ENG-SF20015-R1-TIS.pdf Markup Summary

Memorandum

Full TIS (If the original TIS is older than three years, an entirely new TIS shall be prepared.)

Figure 2  
**Study Area  
 Land Uses**

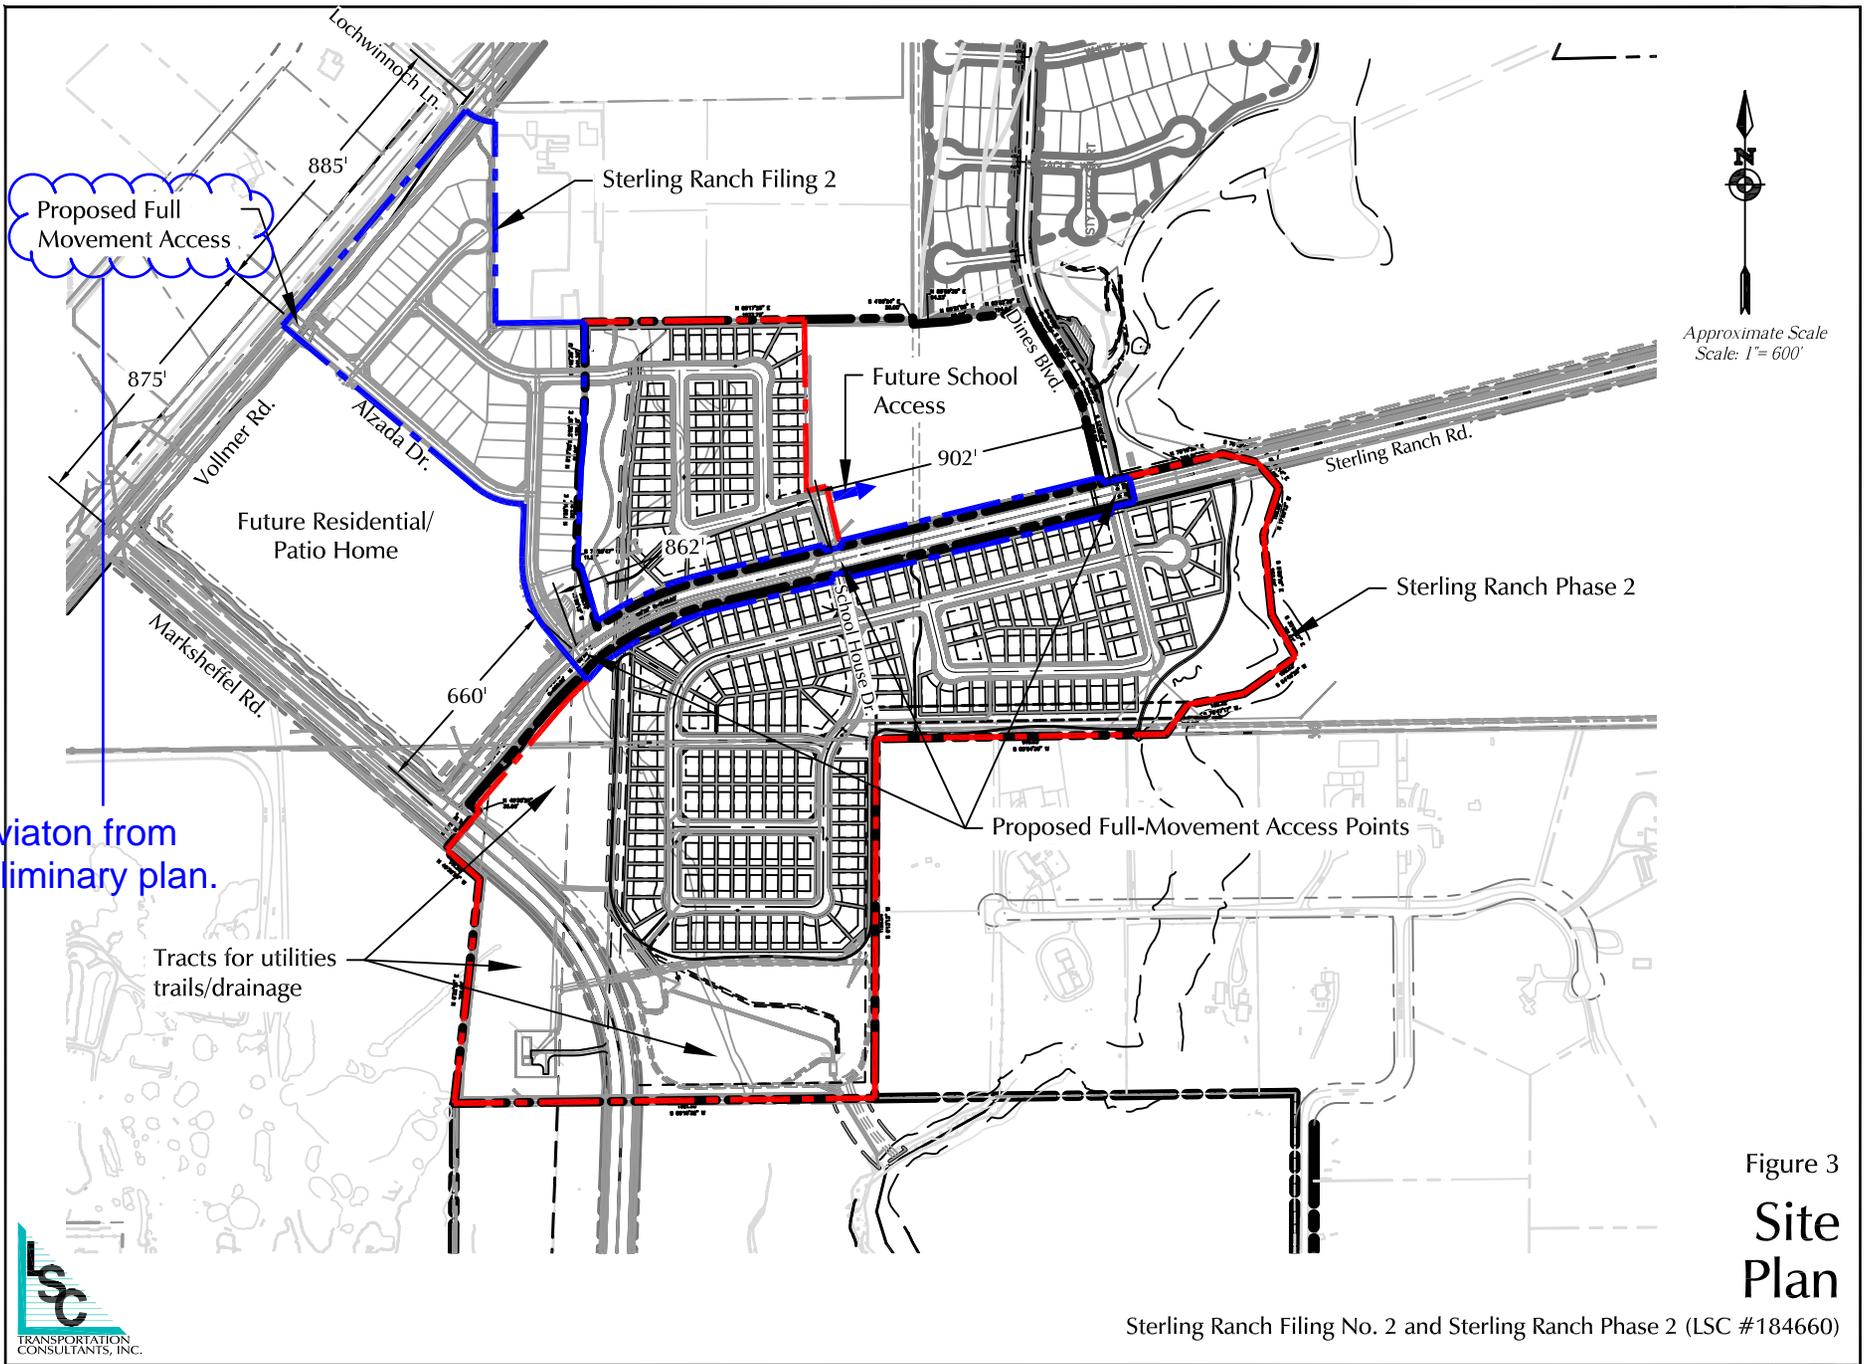
Highlight limits of analysis (road segments and intersections)

Deviaton from preliminary plan.

# Vollmer "Interim" Improvements

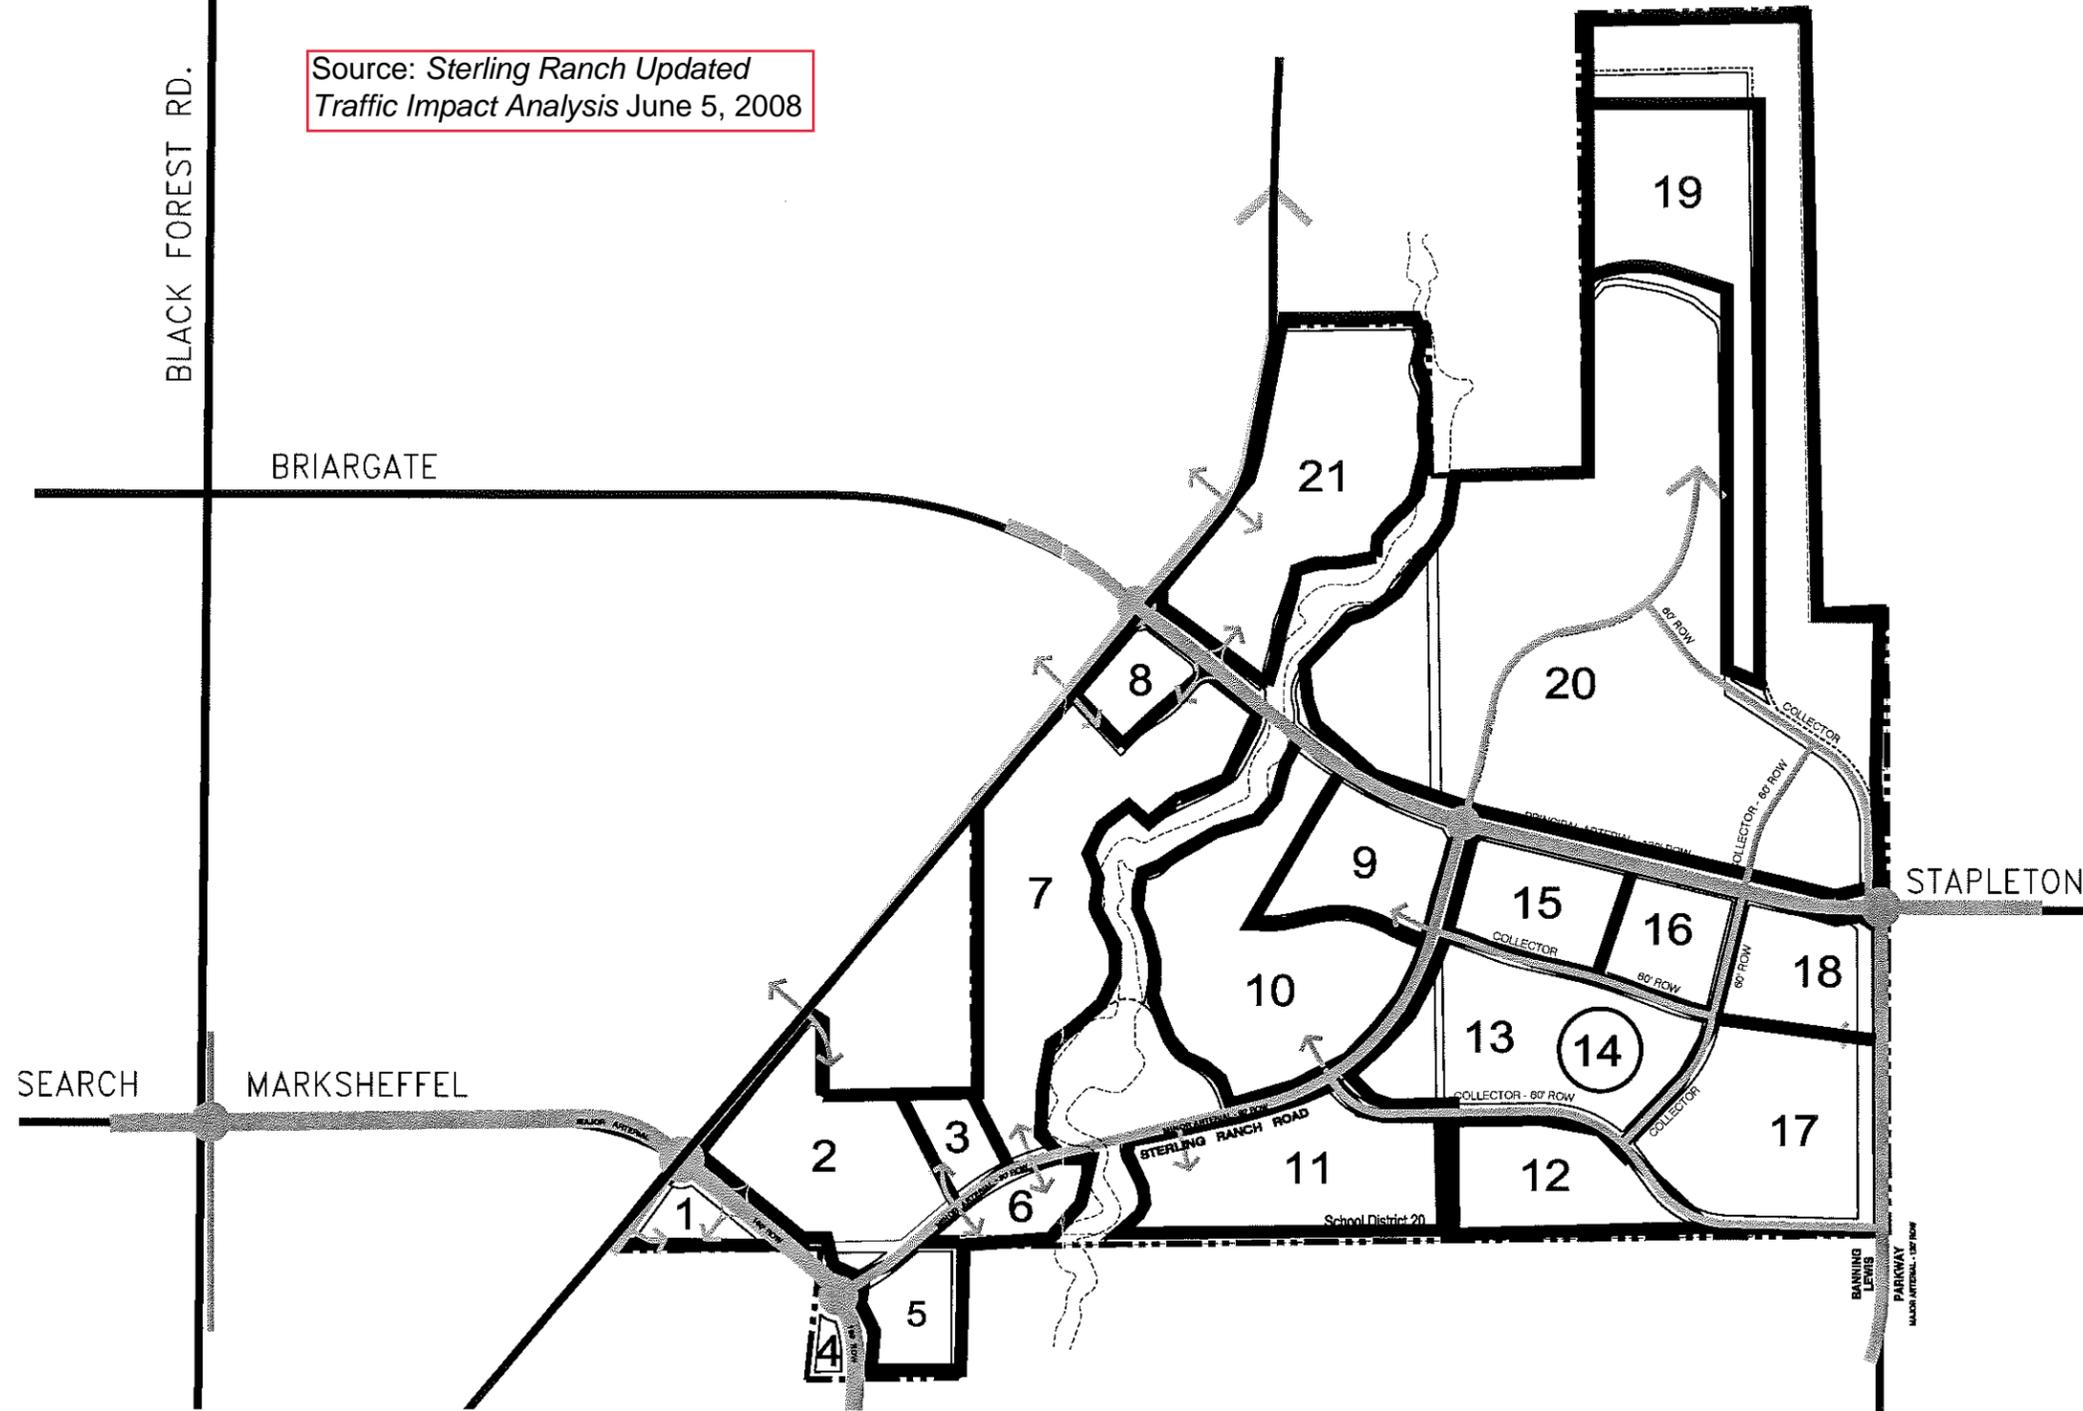
Provide/label the proposed cross-sections.
